**Australian Government**  
**Civil Aviation Safety Authority**

CASA Ref: GI19/605

16 August 2019

Thank you for your letter of 29 July 2019 addressed to Mr Shane Carmody, Chief Executive Officer and Director of Aviation Safety at the Civil Aviation Safety Authority (CASA) regarding the proposed Atlas-Campaspe Mineral Sands Project Modification 1 (SSD 5012 MOD 1). Mr Carmody has asked me to respond on his behalf.

TRONOX
OPTIMISATION MODIFICATION
Modified Atlas-Campaspe Mine
General Arrangement - Year 2

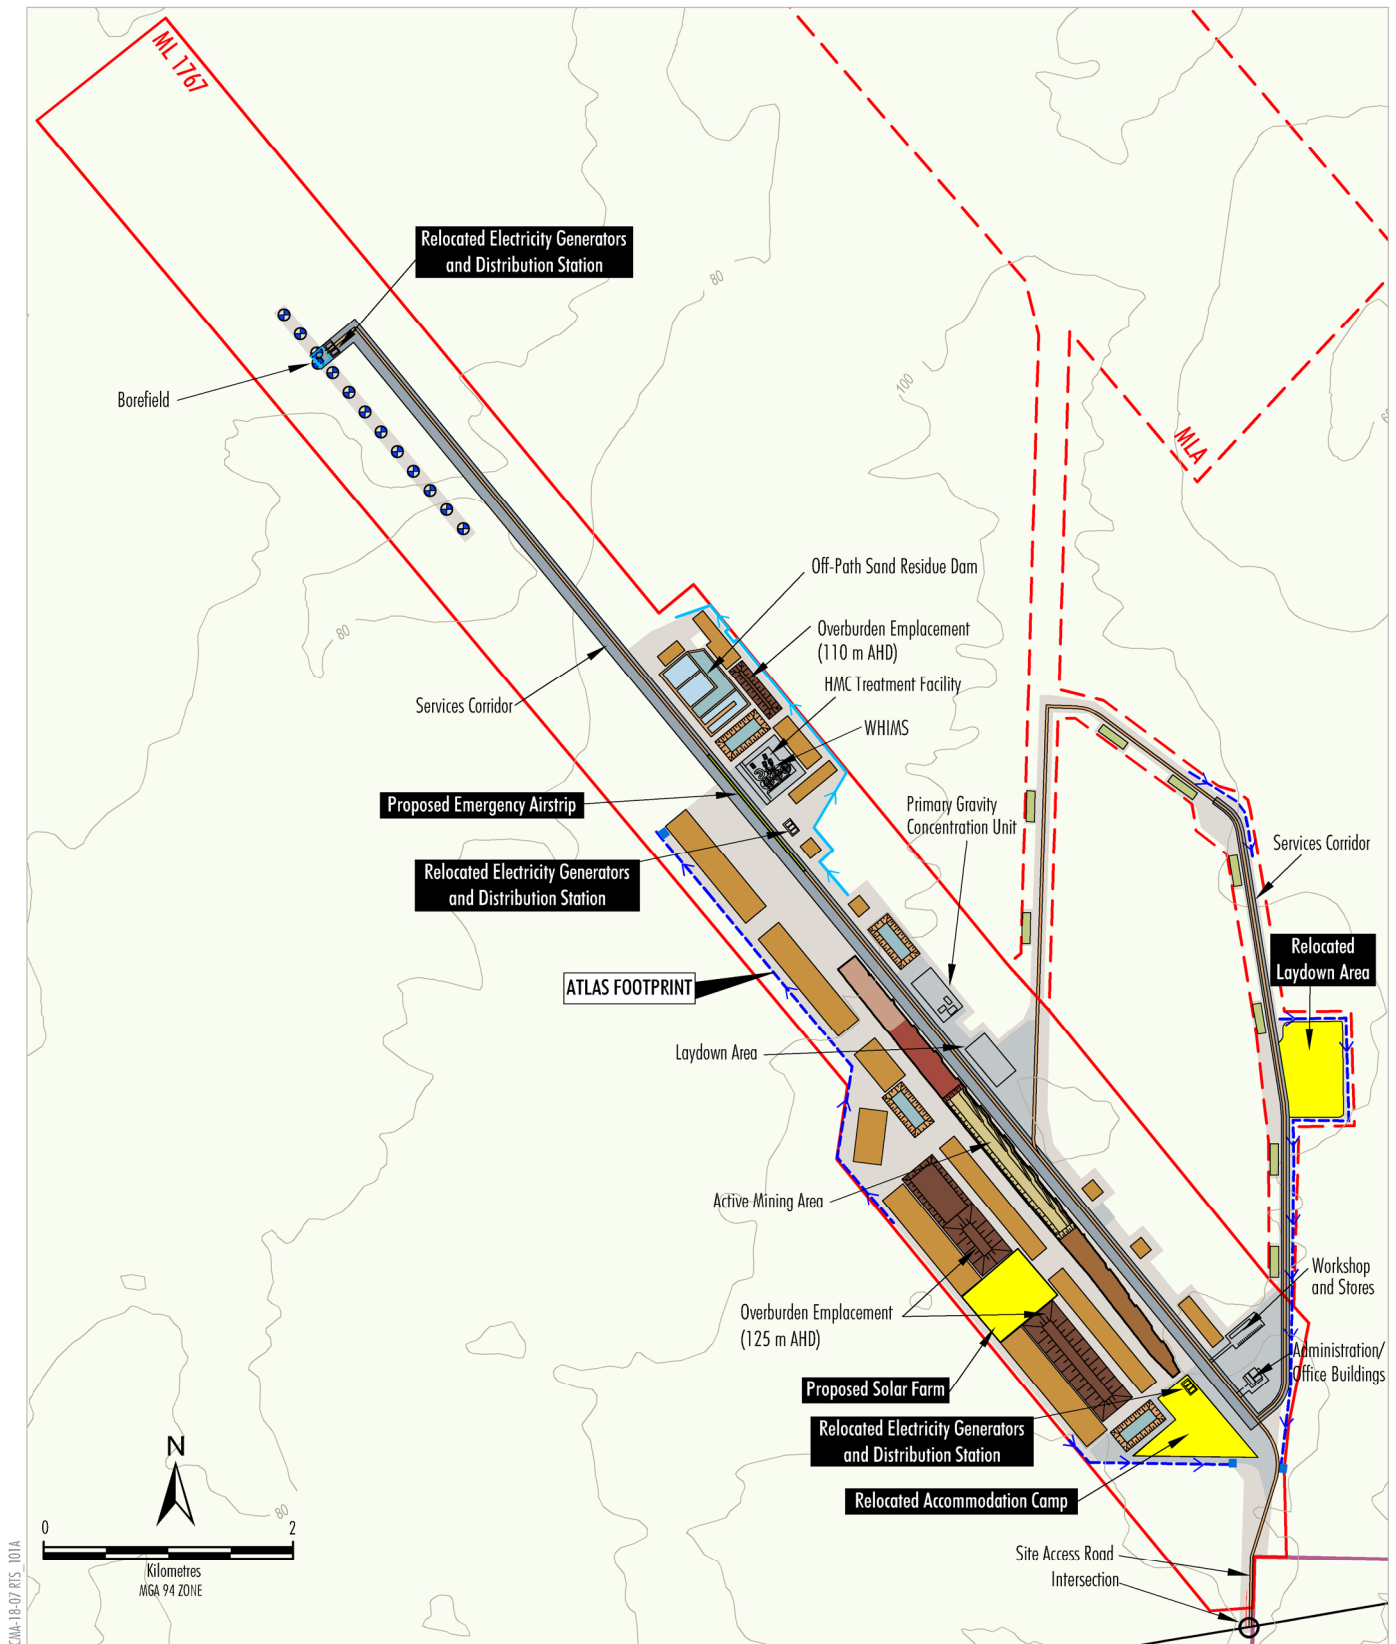
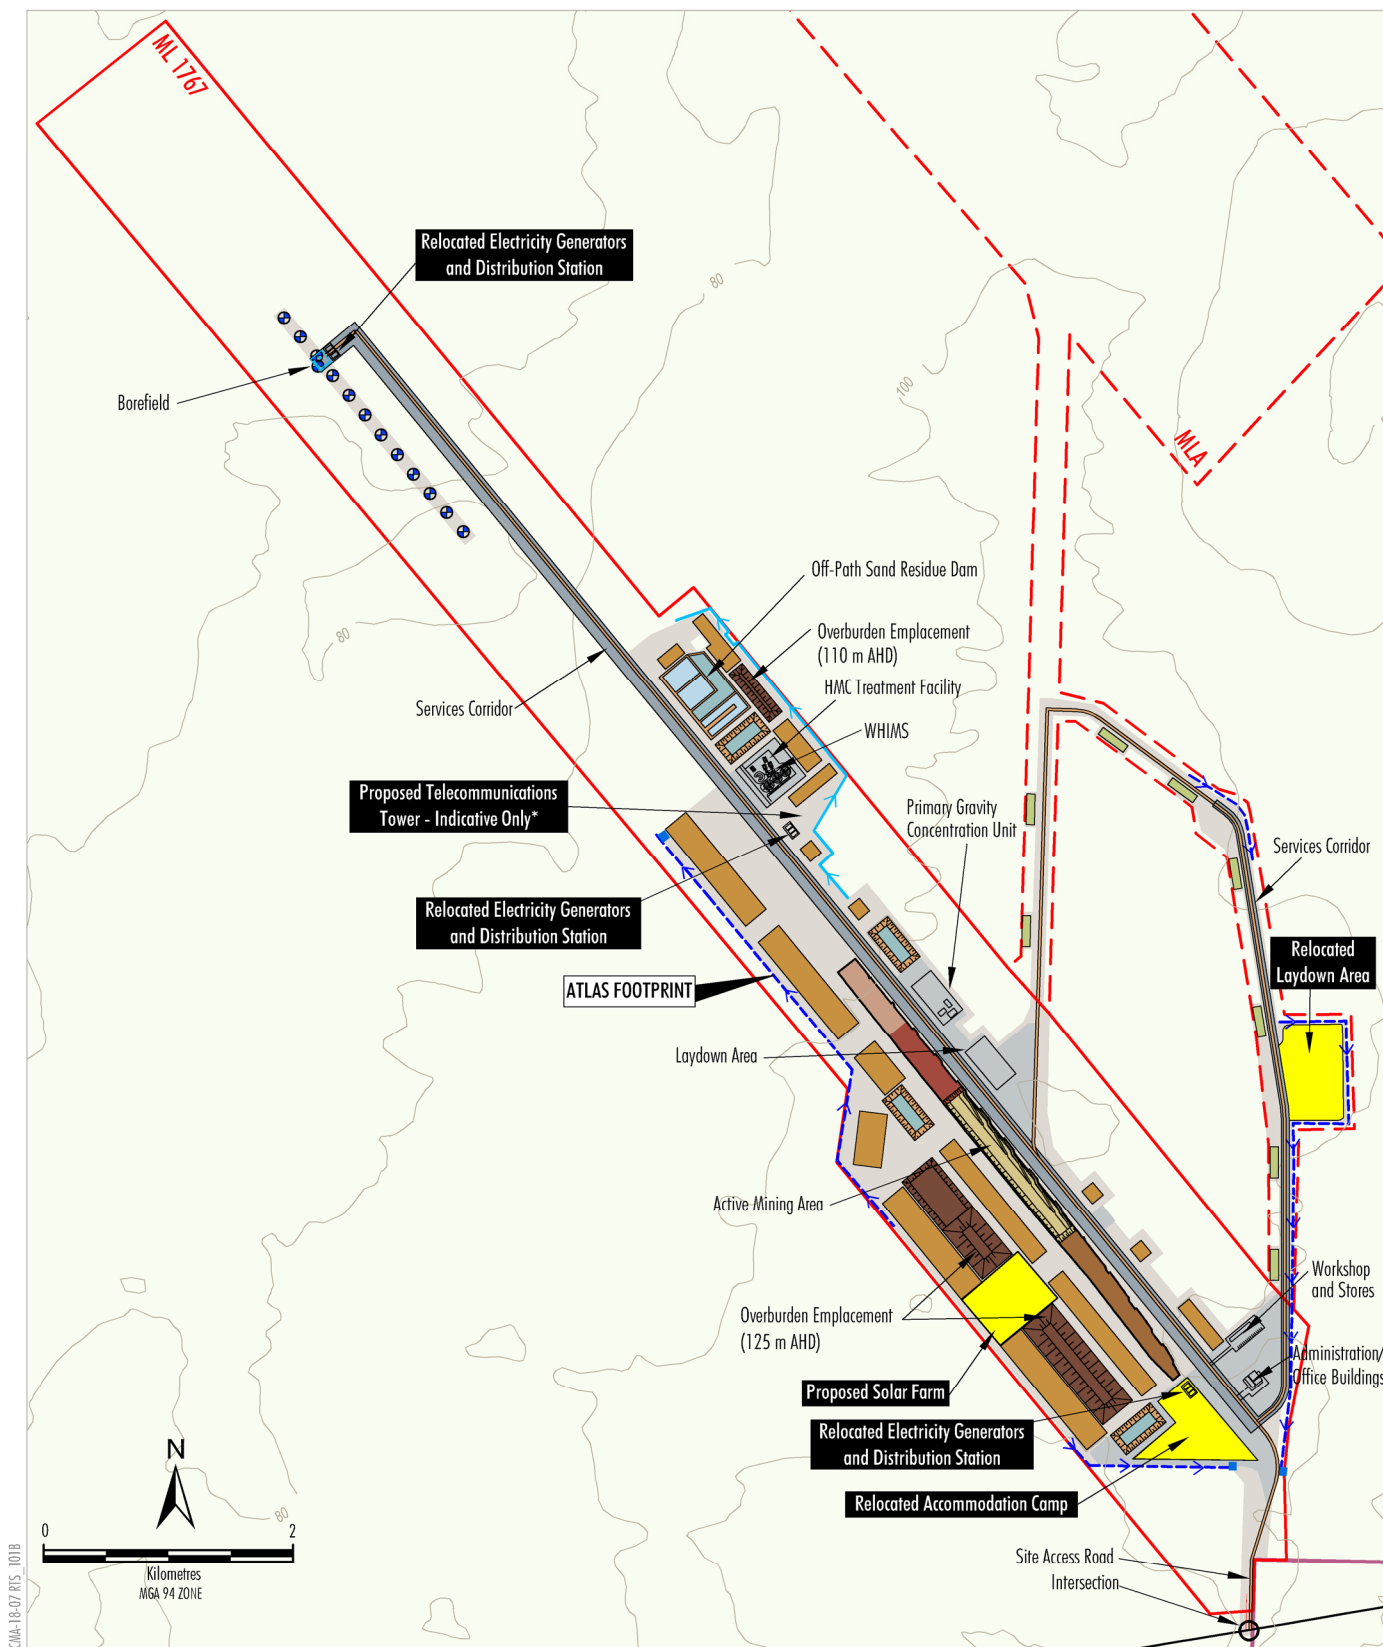
CASA has reviewed the information provided and I am advised that the location of the emergency airstrip is proposed to be on a haulage road which generates a safety risk if there are vehicles on the road at the same time an aircraft seeks to use the road. The surface of a haulage road may not be compatible or safe for aircraft operations. The location as proposed is estimated (by diagram scale) to be 500 metres from an overburden dump. The overburden dump is 110 metres Australian Height Datum which is possibly up to 30 metres higher than the proposed location of the airstrip (based on contour information). This may present a hazard to aircraft safety during landing or departure.

There is a residue dam proposed approximately 300 metres north of the runway "12" threshold which potentially is a source of attraction for birds. There are also five other water storage areas at the proposed mining venture which is a further possible attraction for birds. There is no indication if the aircraft landing area will be fenced to prevent the risk of animal hazard issues. CASA recommends the proponent reviews the National Airports Safeguarding Framework (NASF) guidelines on wildlife hazards and incompatible land use in the vicinity of an aerodrome. Further information on NASF can be found at the following link:

Given the proposed direction and the location of tailings areas, there is the possibility of mechanical wind turbulence being generated under certain wind conditions that may affect the safety of aircraft operations.

CASA notes that there is no information provided in relation to the possibility of night operations which will require lighting to support aircraft operations, and consideration should be given to the potential for pilot visibility to be impacted by lighting on the mine site buildings and operational areas. CASA also notes that the Royal Flying Doctor Service has been invited for comment on the proposal and their comments from an operational perspective will be informative.
